FP/45 120/NMA

Application for a non-material amendment following a grant of planning permission. Town and Country Planning Act 1990

SINGLE STOREY REAR EXTENSION & NEW
WINDOW ON GROUND FLOOR EAST ELEVATION .

FP/227/19/HH

Drawing Title
**PROPOSED PLANS
& ELEVATIONS**

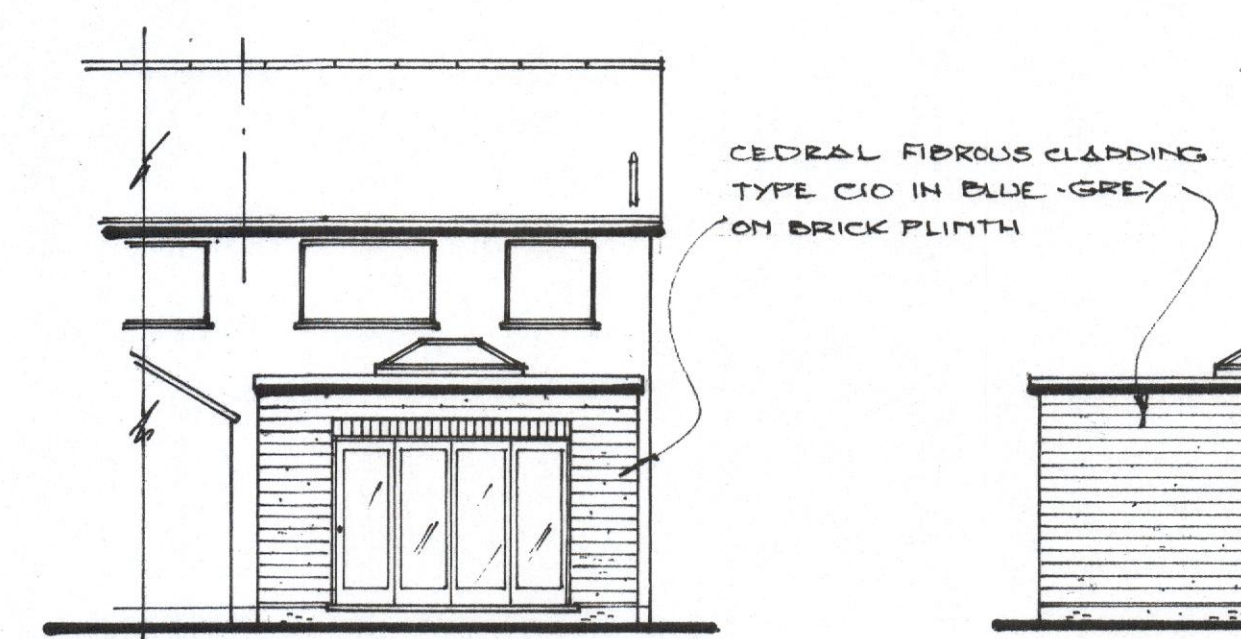
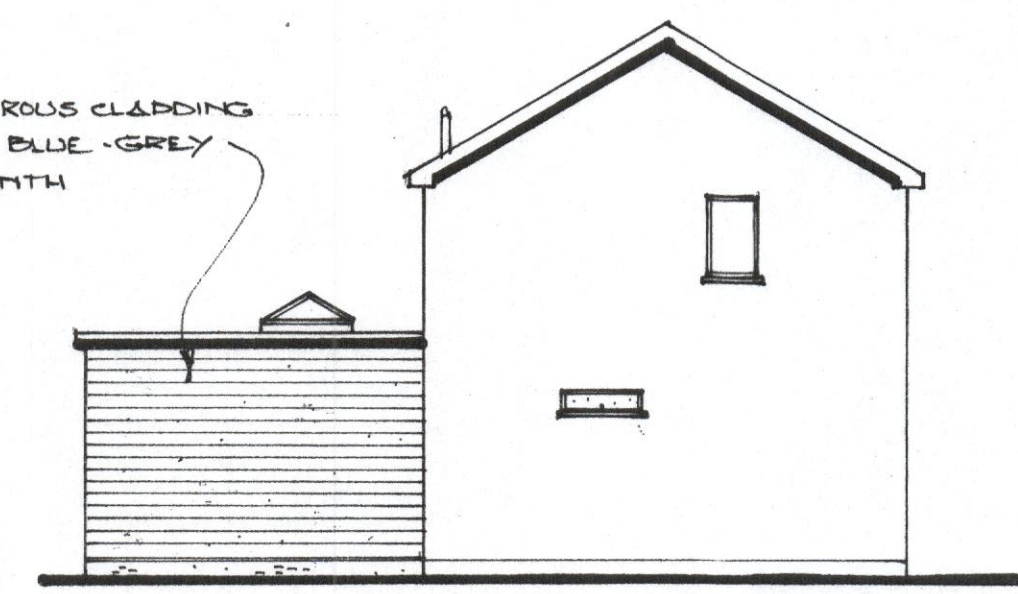
CHANGE REAR & EAST ELEVATION WALLS
FROM FACING BRICKWORK TO MARLEY CEDRAL
CLADDING TYPE C10 IN BLUE-GREY, WITH
FACING BRICKWORK BELOW D.P.C
